**RE: Sandia Area Credit Union and Starbucks, 11301 Montgomery Boulevard
Grading and Drainage Plan
Engineer's Stamp Date 6-01-2015 (File: F22-D002)**

Based upon the information provided in your submittal received 6-01-15, the above referenced plan cannot be approved for Building Permit until the following comments are addressed:

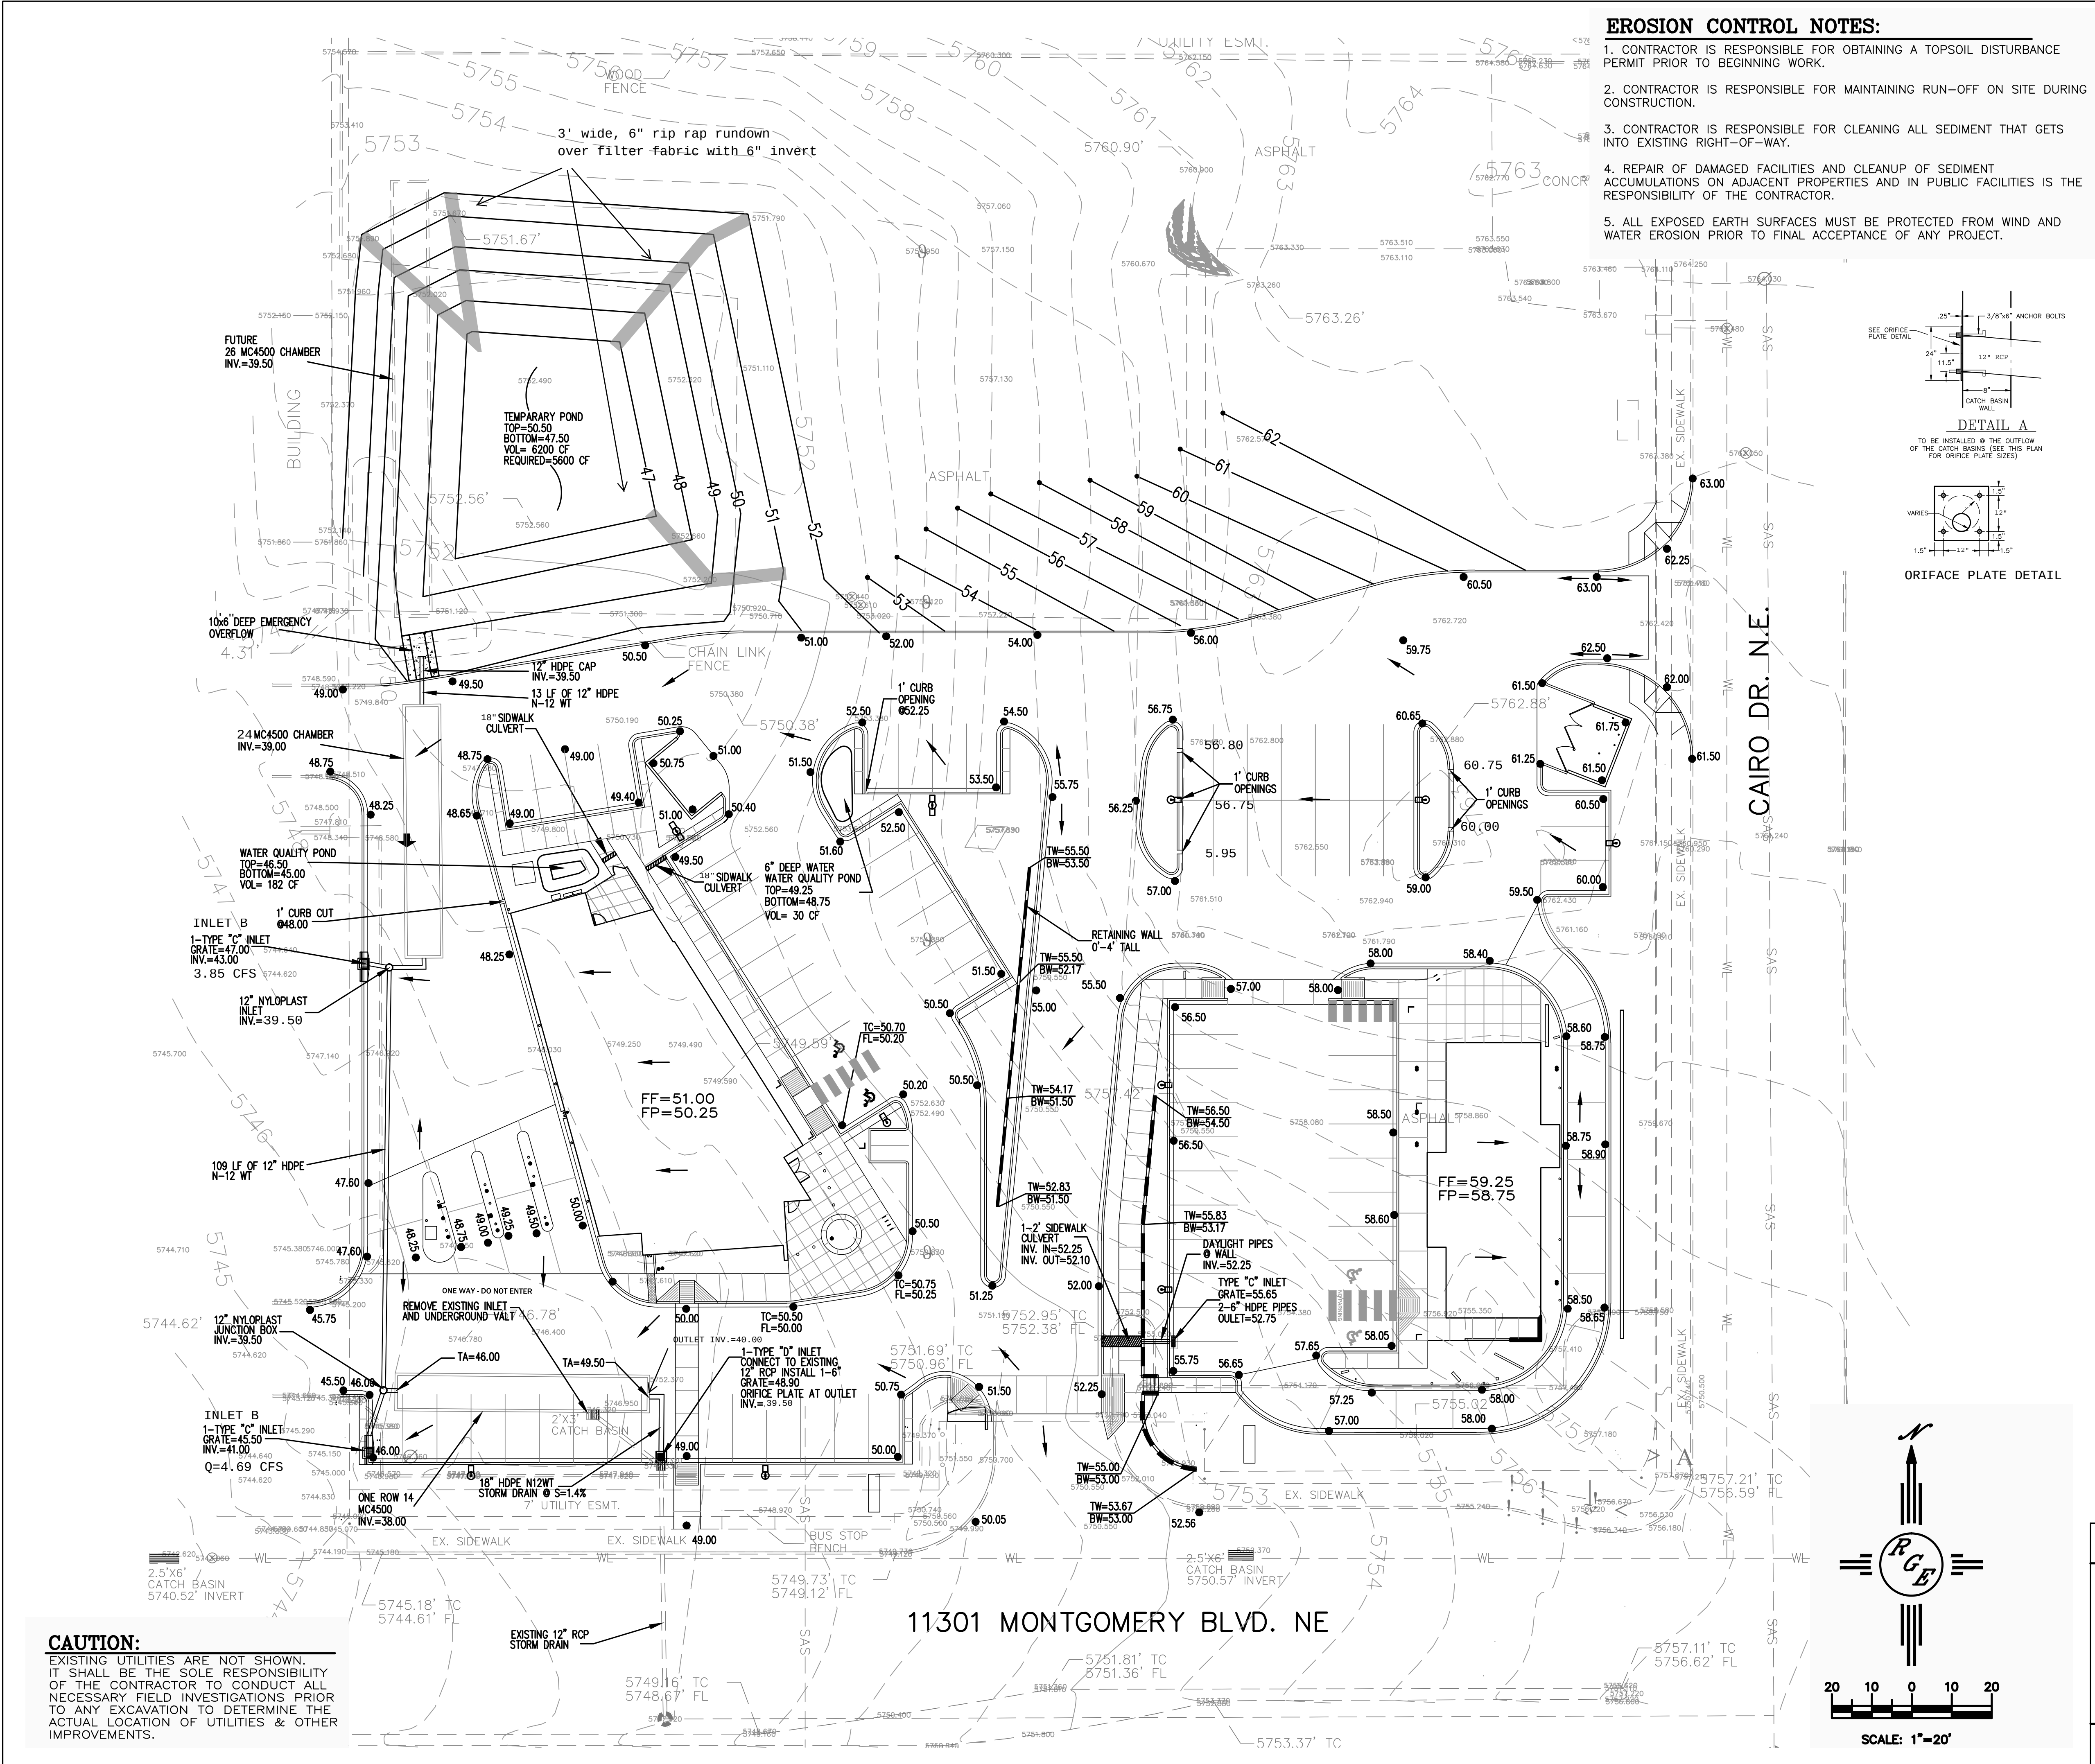
- 1) Show first flush calculation within the report. Show roof drain locations, and explain how first flush is being managed especially with regard to impervious facilities on the east side of the site. It appears as though an additional first flush pond may be needed to handle first flush from the building on the southeast corner of the site with added curb cuts to allow drainage into the pond from the drive-thru area. Label all first flush ponds as "first flush" along with volume information.

- 2) Show flow arrows and lot lines on the grading and drainage plan.
- 3) What are the curb cuts in the medians to the north of the Starbucks for? If a first flush pond was intended here, label it, and provide elevation and volume information. Provide curb flowline elevations at all curb openings.

- 4) Show existing curb elevations on Cairo at the access point, and show existing elevations along west property line to show how these existing elevations relate to new elevations. On the north side of the site, provide elevations for the existing building that abuts the property line, and ensure that the new contours tie into the correct existing contours.

- 5) Discuss what the temporary pond is for. What is the sizing of it based on since the 100-year 6-hour volume is much higher for Basin A? Discuss what the plans are for Basin A since an impervious area of 0.988 acres was given in the computations.

Also provide riprap within the proposed swale to the bottom of the pond from the east to prevent erosion.

7) Label grate elevation for the new Type "D" inlet. Provide a detail showing all elevation information for inlet including information for orifice. Show how this inlet ties into the storm chambers with pipe invert and size information.

8) Label size of Nyloplast junction boxes and the pipes that tie into the storm chambers. Between the high invert elevation of 48.00 for discharge from the site and the high invert elevations of the connecting nyloplast junction boxes, how does the entire system manage to drain, given that the top of the storm chambers are set at elevation 42.50??

13) North of the credit union building, there is a curb cut elevation at an elevation of 49.40 which should be lowered if the intent is to drain to the "water quality pond". Also, the nearby "water quality" pond is labeled at an elevation of 46.50 for the top elevation. Correct discrepancy. Also, provide additional elevation information for the corners of the trash receptacle area.

16) Provide a small valley gutter from the sidewalk culvert from Starbucks across the accessway to prevent flow from discharging out the accessway.

MULTIPLE CHAMBERS NOT USED FOR THIS APPLICATION

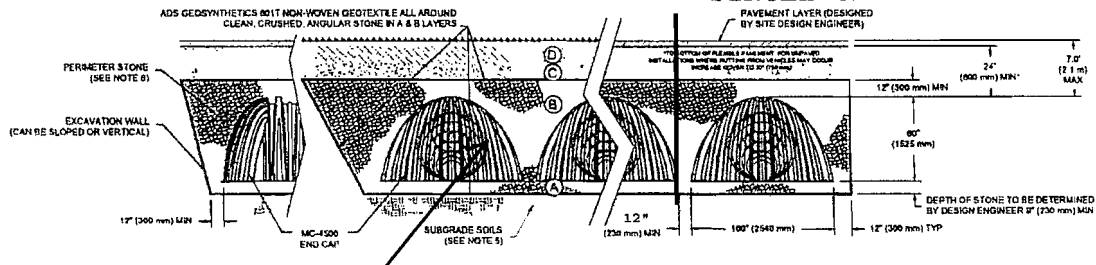
11) On the proposed layout for the storm chambers with the report, label the number of chambers used and the volume of each chamber. Then provide the overall volume of the chamber on this sheet and on the plan view. Provide a cross-sectional view of the storm chamber similar to what is shown on the report showing a detail of the stone and fabric surrounding it if it is just for one row. (It should be similar to the cross-section provided in the report for the multiple chambers.)
